CITY OF PORTLAND, MAINE

July 22, 2015

Project Name: **Bangor Savings Bank Bank/Office building with two lane drive-through**
Project ID: #2015-080
Address: 20 Marginal Way CBL: 113 A 025001
Applicant: Wendy Durrah, Bangor Savings Bank
Planner: Jean Fraser

EXTERIOR ELEVATIONS

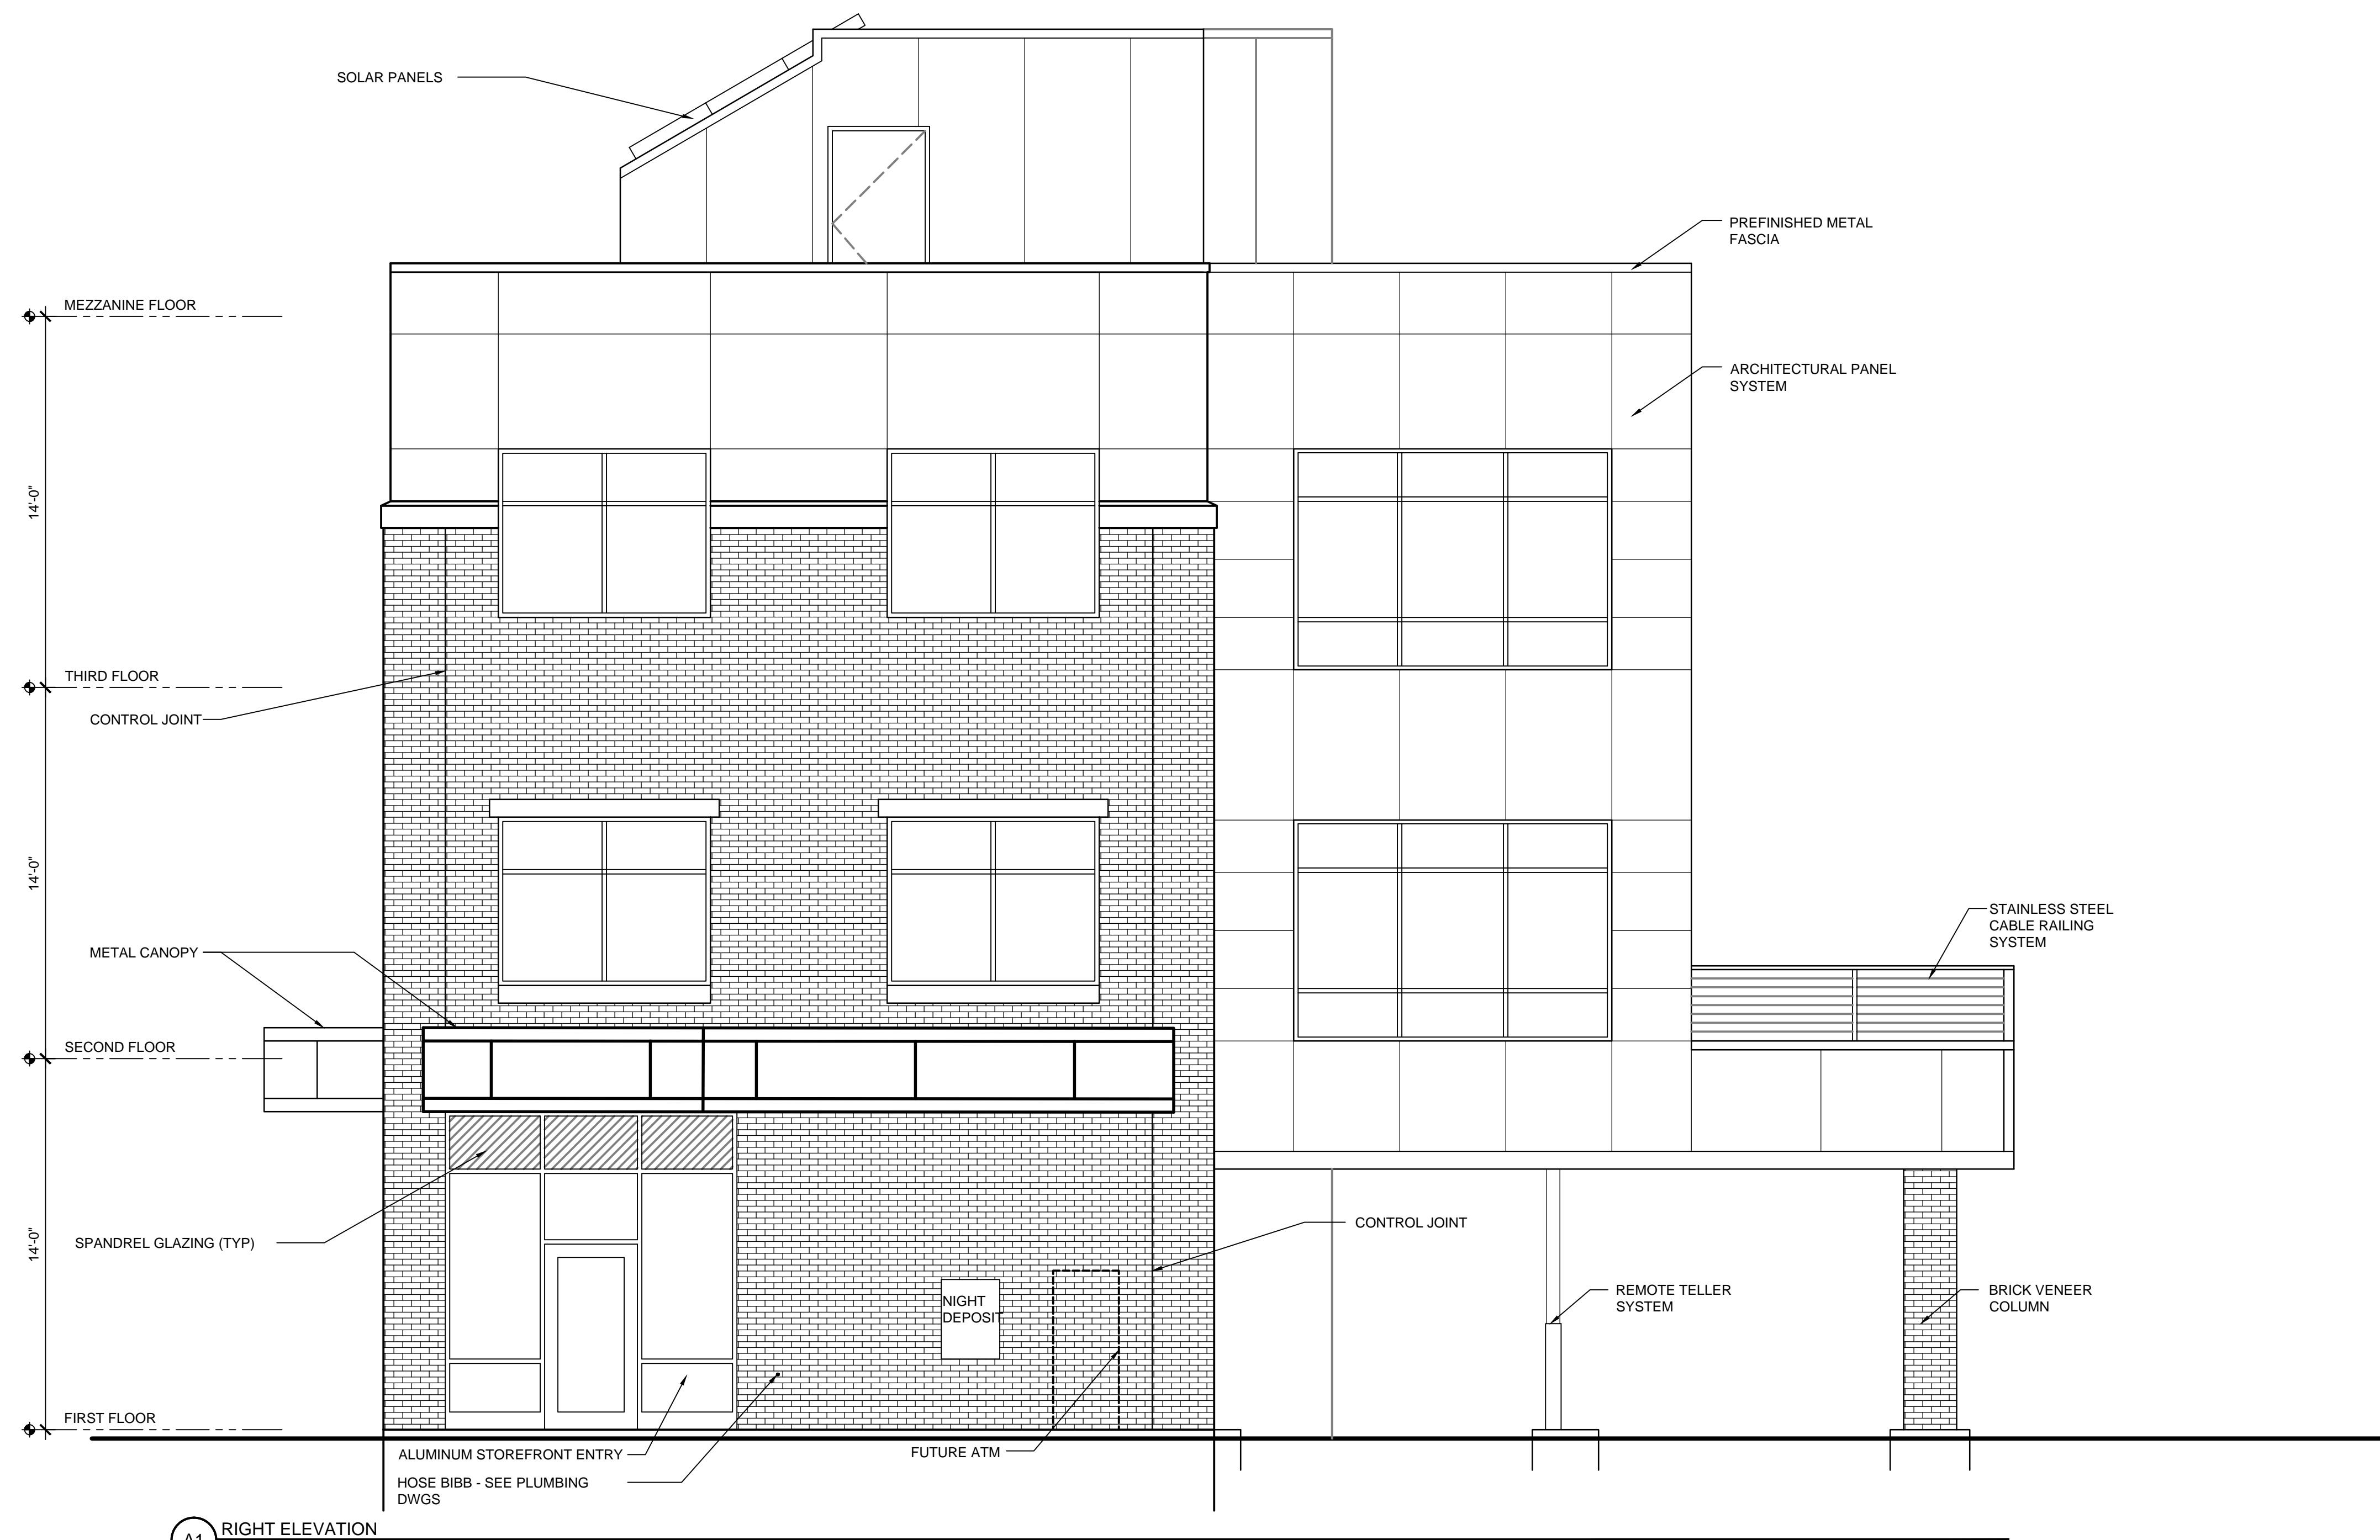
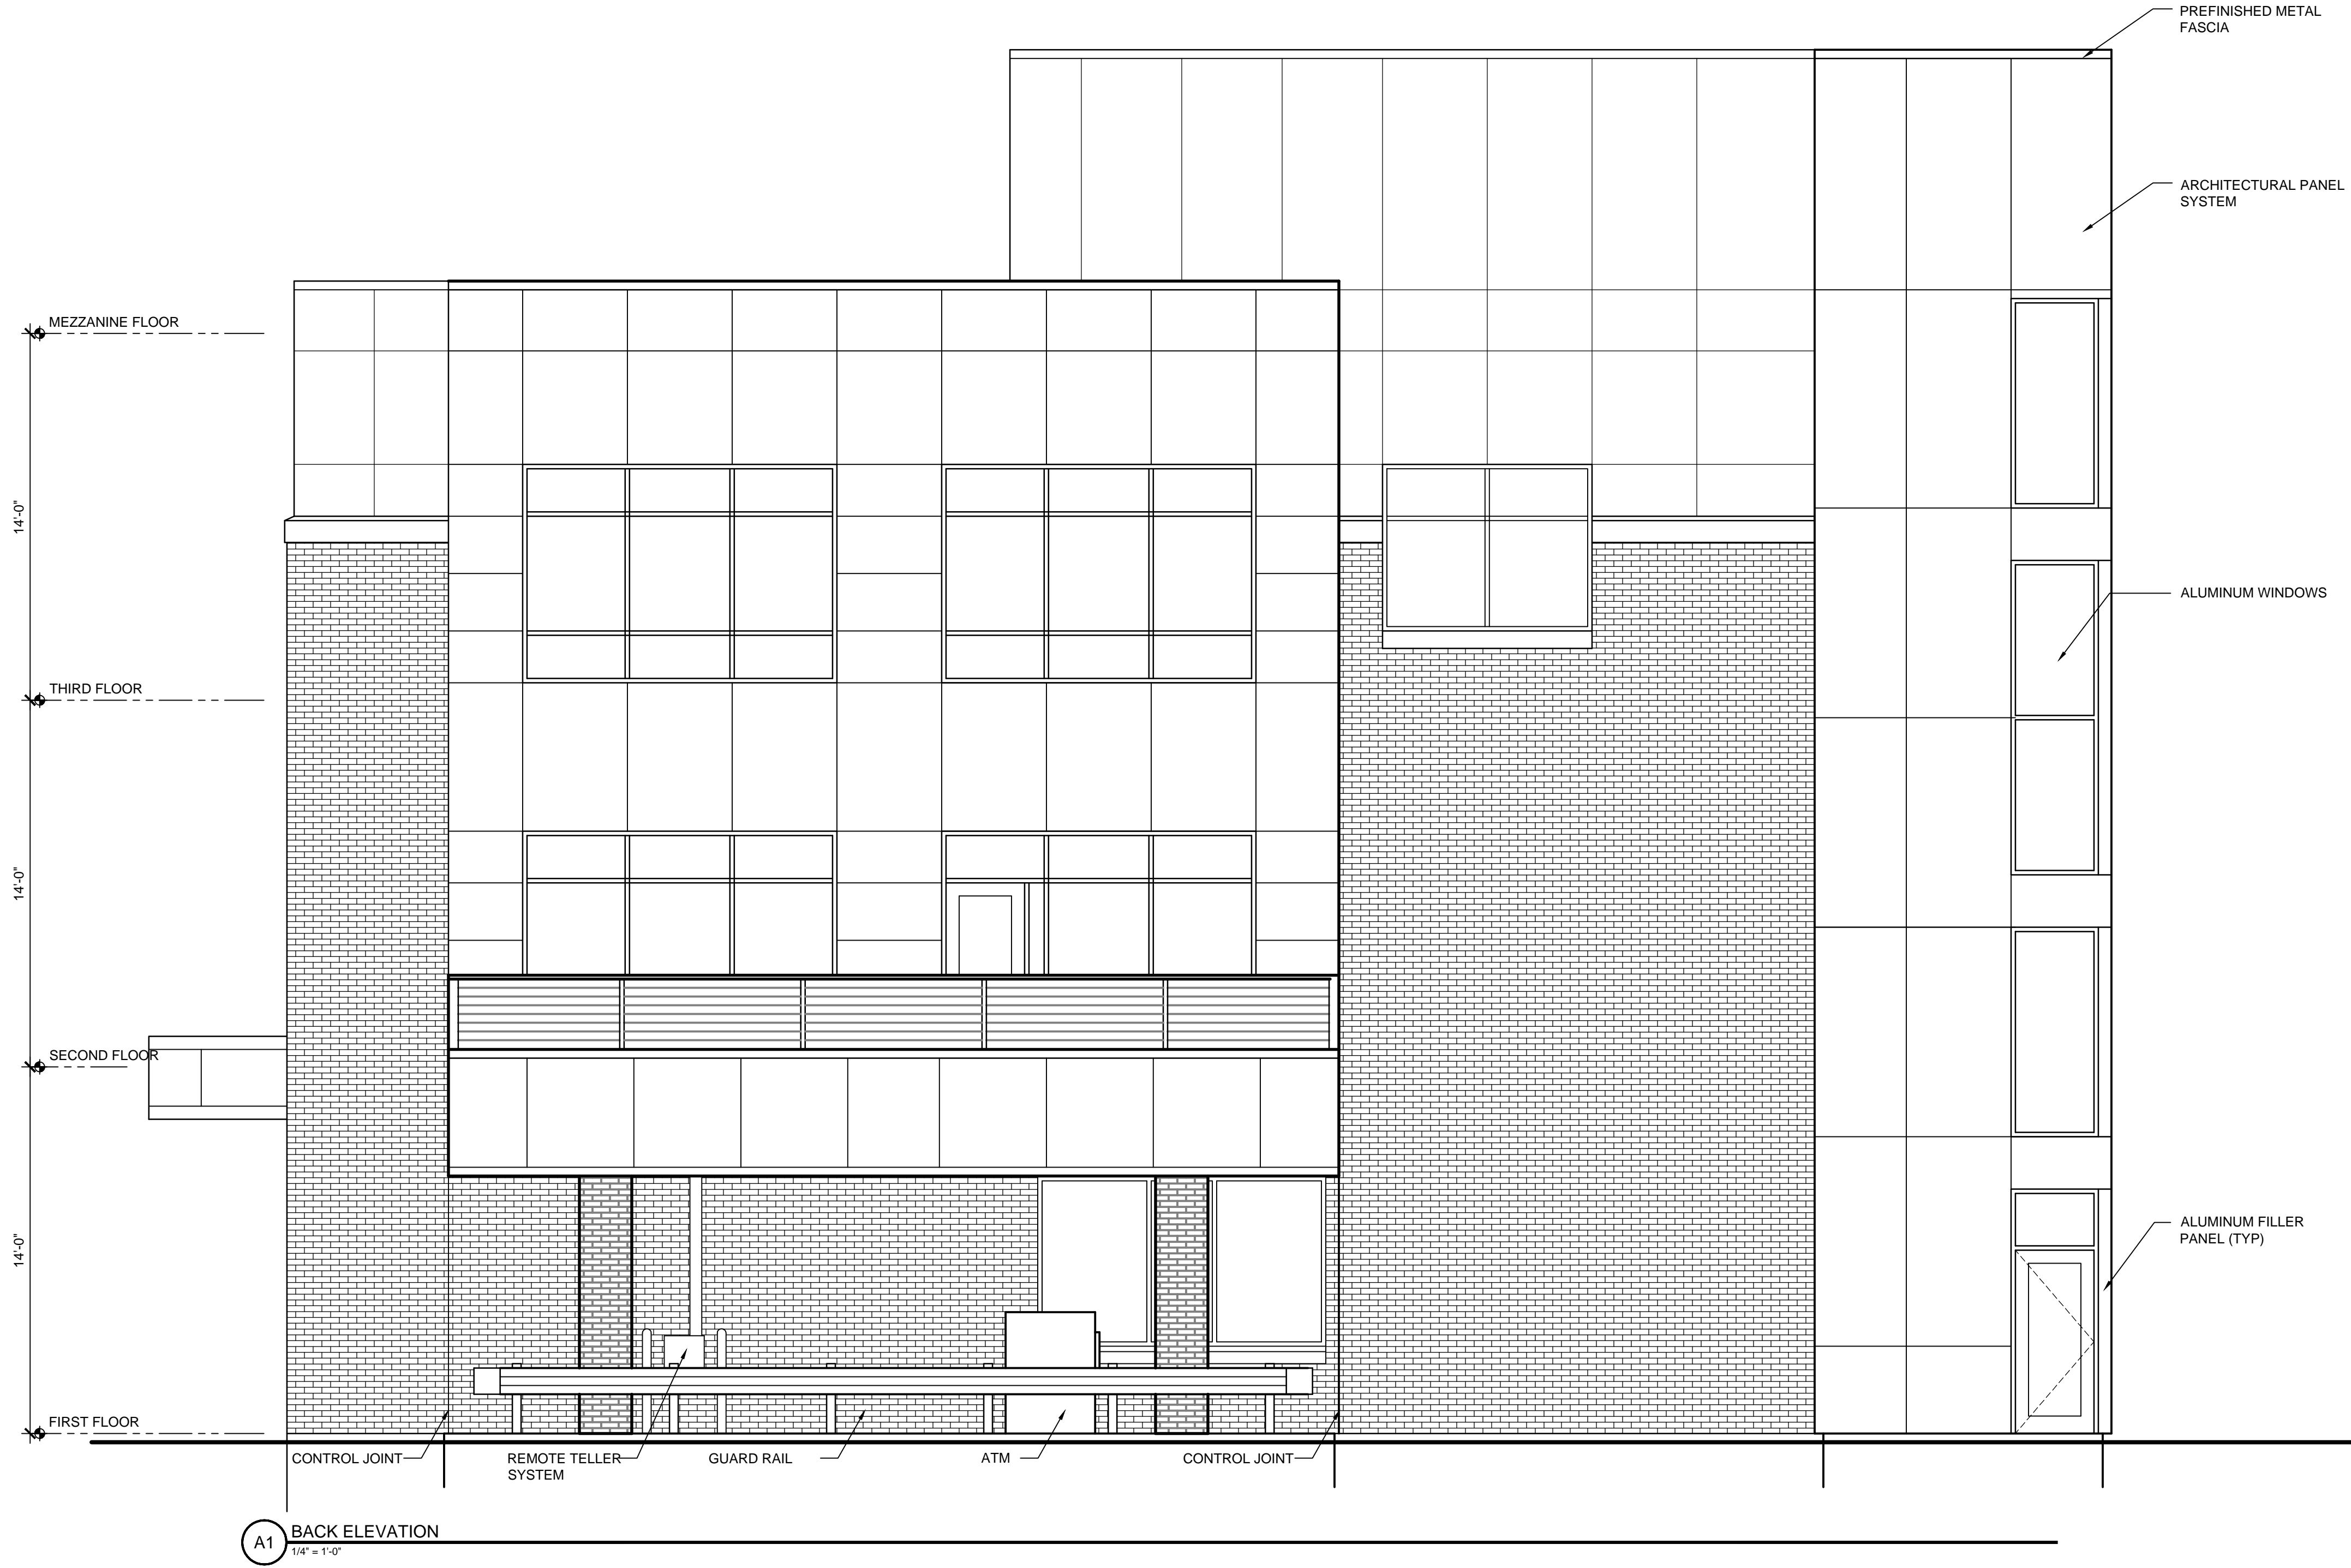
- **Proposed glass has a VLT of .56 which is lower than the allowed .7. A sample is required** before staff can assess whether the transparency is adequate.
- **Spandrel glass (opaque) is proposed** for the upper portion of the ground floor storefront which is **not allowed by the Standard. See comments below.**

- **Proposed transparency does not meet the Standard.**
- **Spandrel glass (opaque) is proposed** for the upper portion of the ground floor storefront **which is not allowed by the Standard. Staff does not support the use of spandrel glass in this project. Staff recommends that the ground floor windows be reduced in height** (and the canopy subsequently lowered) and the area where spandrel glass is proposed be eliminated. Reducing the amount of glazing will also reduce the solar gain in the façade.

- **Proposed glass has a VLT of .56 which is lower than the allowed .7. A sample is required** before staff can assess whether the transparency is adequate.
- **Proposed glass has a green tint** which is not allowed by the Standard. **Glazing should look clear. A sample is required** before staff can assess whether the color is adequate.
- **Spandrel glass (opaque) is proposed** for the upper portion of the ground floor storefront **which is not allowed by the Standard. See comments above.**

- ii. That the Planning Board has established that the maximum level of parking is 24 parking spaces; and
- iii. That the applicant shall reconsider the window design, including transparency, color, and size, in consultation with the City's Urban Designer, to meet the intent of the B-7 Design Principles and Standards. The final design to be reviewed and approved by the Planning Authority prior to the issuance of a building permit; and
